Re: Professional Engineer's Certification of Permanent Control Measure
Flying Horse North Filing No. 4, Pond A

This letter serves as a Pond Certification for the constructed Full Spectrum Detention Facility "Pond A" located in Flying Horse North Filing No. 4. The permanent control measure is located at the southeast area of the subdivision, near Black Forest Road and north of Rubble Drive.

POND A GRADING PLAN

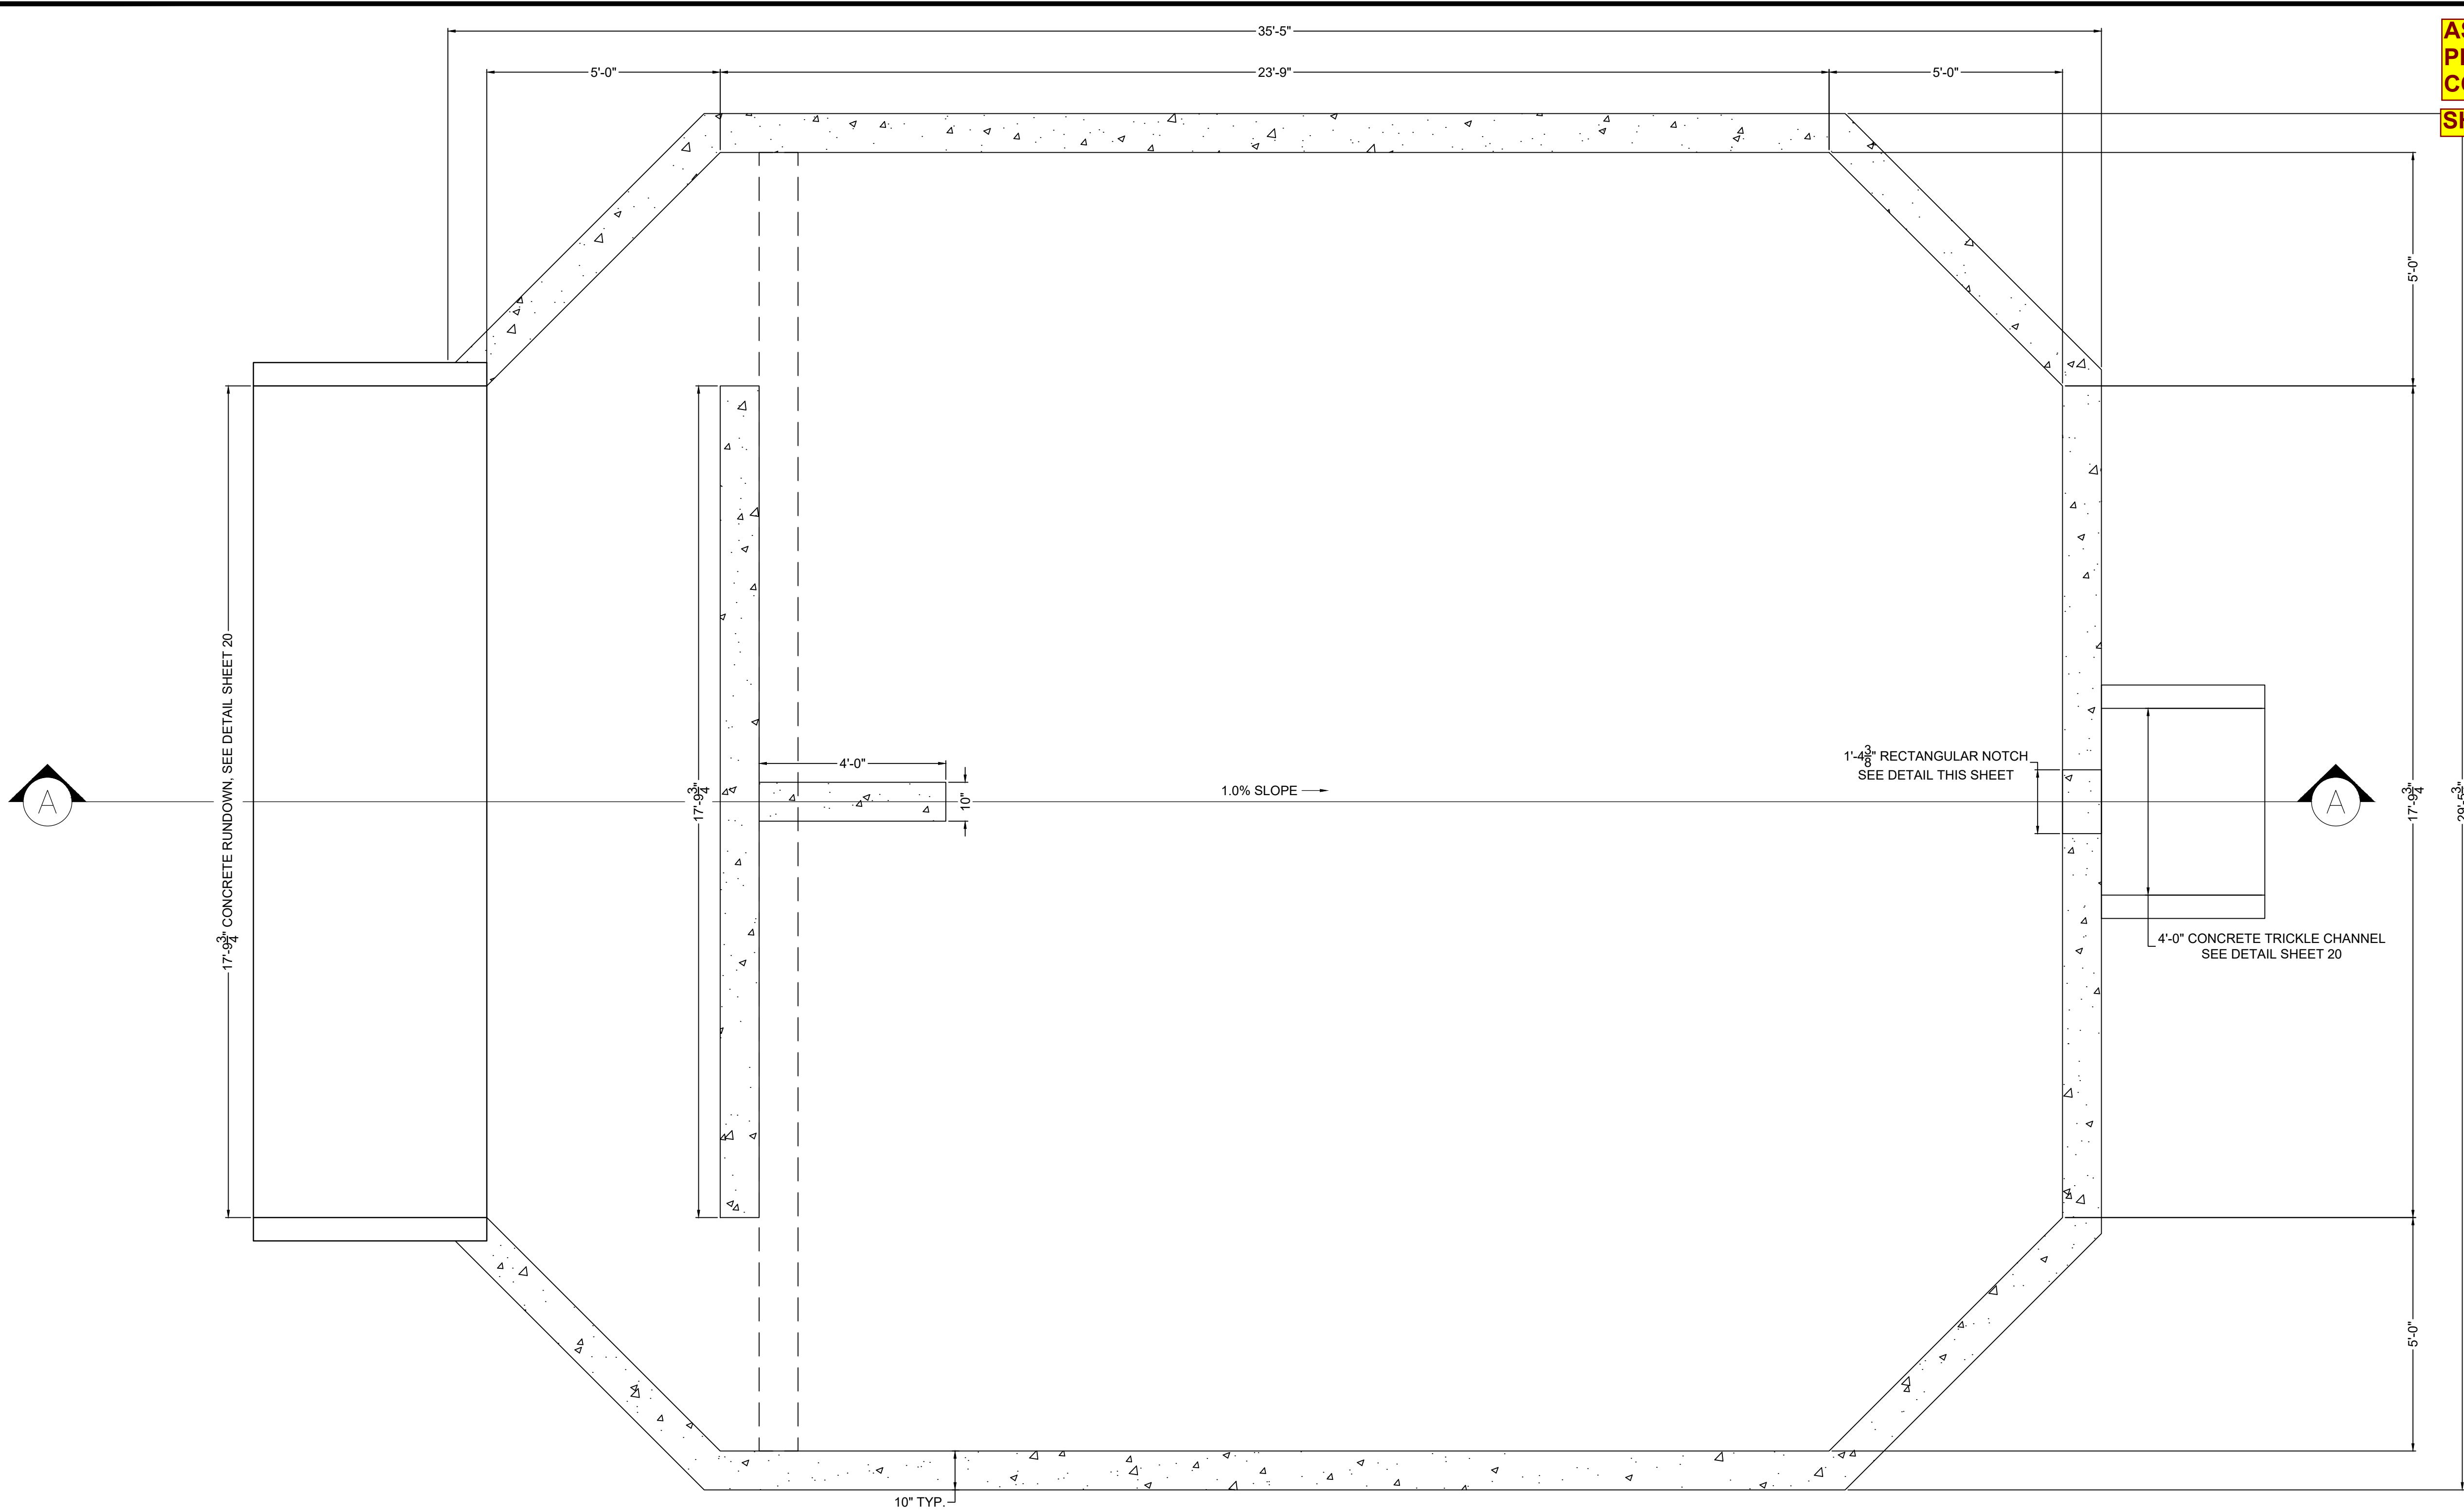
- Inflow Riprap Upstream of Forebay
 - The riprap inflow is inundated with sediment and is not installed per the approved plans. Buried riprap is shown on the approved plans. Install per approved plans or consult the Engineer of Record. See Note 1. **All exposed rip-rap is now buried soil rip-rap with top soil and permanent seeding for stabilization.**

- Also, the riprap has no low-flow conveyance, such that as it has accumulated sediment in the middle of the width, the flows have been pushed to the outside of the riprap and is eroding around the sides of the riprap. Installing riprap with a V shape (per plans) or U shape would better prevent flows from causing erosion of the swale side slopes, and/or install riprap on side slopes. **A more defined V-shaped swale has been constructed. The rip-rap pad is revised per the as-built redlines and the remaining channelized section is TRM lined with permanent seeding for stabilization.**

- Forebay
 - Remove sediment from the forebay. **Sediment removed.**
- Trickle Channel
 - Remove sediment from the trickle channel. **Sediment removed.**

- Outfall Riprap
 - Outfall riprap is not installed per the approved plans. Plans show buried riprap and in the field it is installed as exposed riprap. Install per approved plans or consult the Engineer of Record. See Note 1. ***Outfall/spillway rip-rap is exposed rip-rap and is now reflected on the as-builts, as approved by the Engineer of Record.***

- Also, the riprap apron is not shaped to convey flows. It is piled up such that there is no positive drainage and flows will just bypass the riprap and cause erosion. So please reconfigure riprap to properly convey flows. ***A more defined conveyance V-shape swale has been constructed.***

- Maintenance access road installed with crushed concrete, which per direction from CDPHE is not an acceptable means of Final Stabilization, nor was that material on the approved plans, so please remove and install access road material per plans. ***As-built plans and redlines now call out crushed concrete as approved by the Engineer of Record. This was discussed with Stormwater staff in July 2026 and is to be allowable for this filing.***

POND DETAILS
POND A FOREBAY

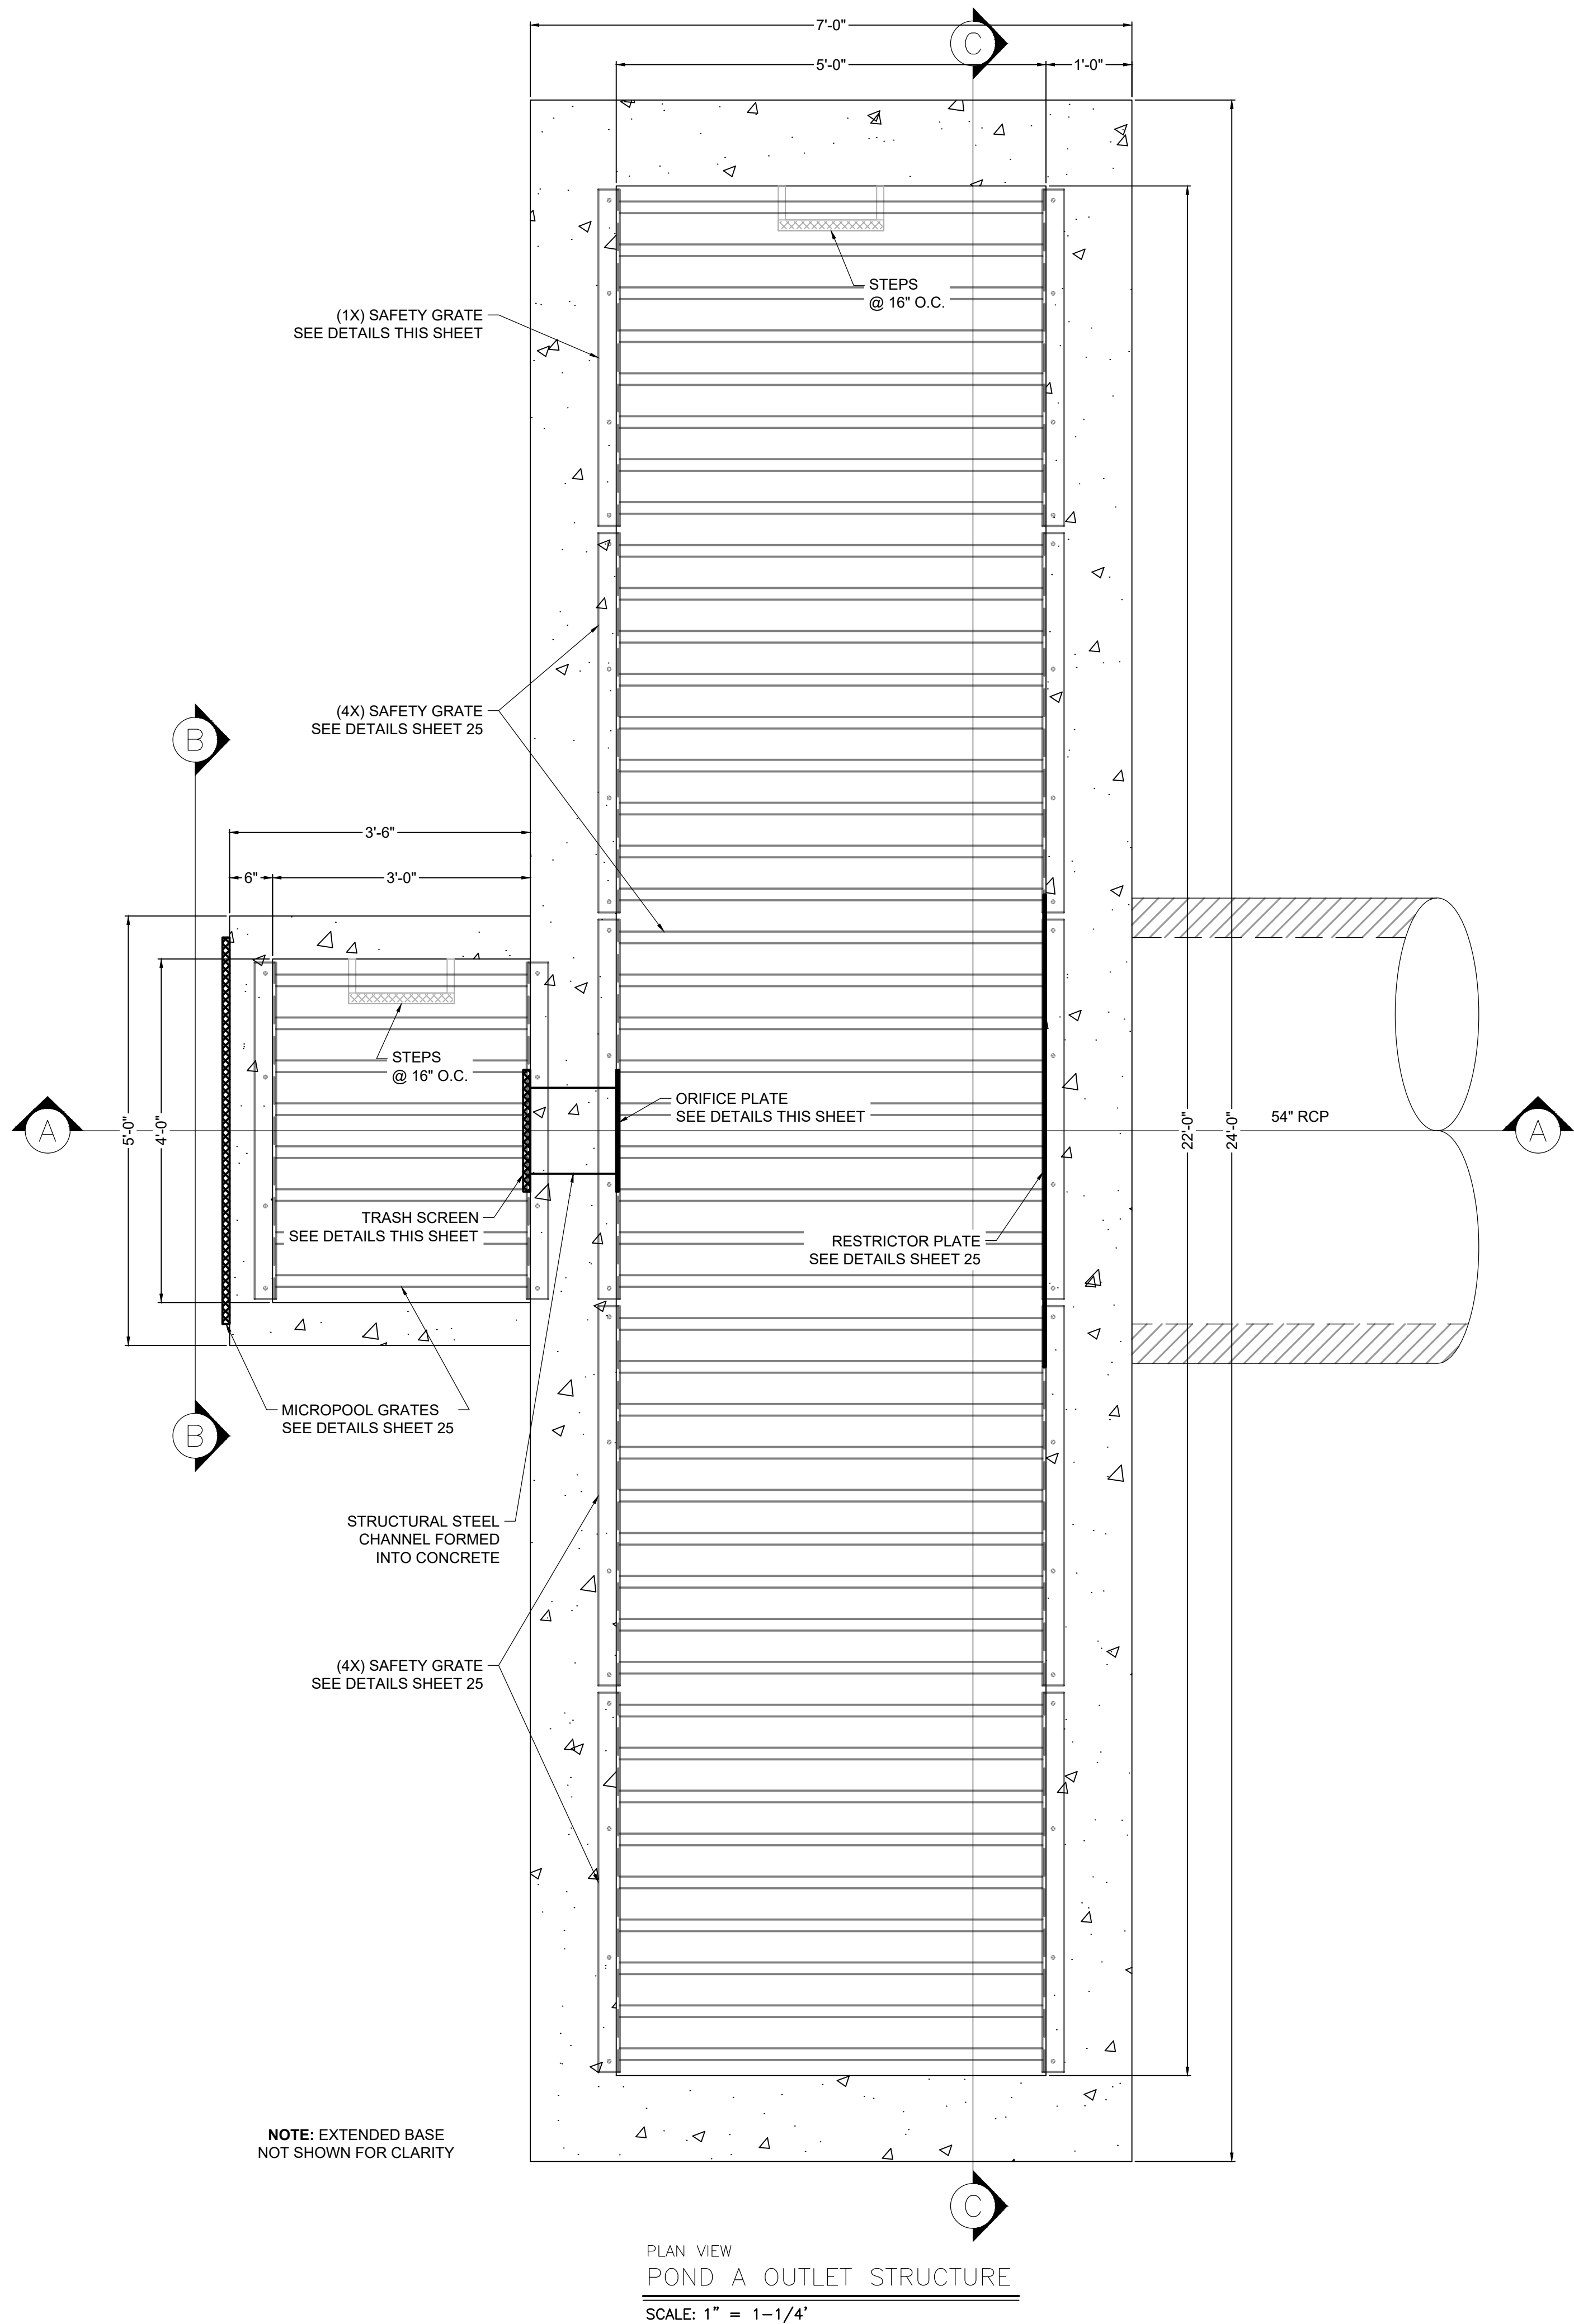
- Outlet Structure
 - The distance between orifice holes is not installed per the approved plans. The holes are 12in apart and should be 10.8in apart. Install per approved plans or consult the Engineer of Record. See Note 1. ***As-built redlines supplied to reflect the revision to the orifice plate. MHFD Detention calculations supplied with the Pond Certification letter support the change.***

- Gasket appears to be leaking. Ensure the gasket is watertight and does not allow water to leak out the sides. ***New gasket fittings installed to ensure watertight condition.***

- Remove sediment and debris from the outlet structure. ***Sediment removed.***
 - Ladder steps missing in micro pool. Install per approved plans or consult the Engineer of Record. See Note 1. ***Ladder steps installed to match Construction Drawings.***
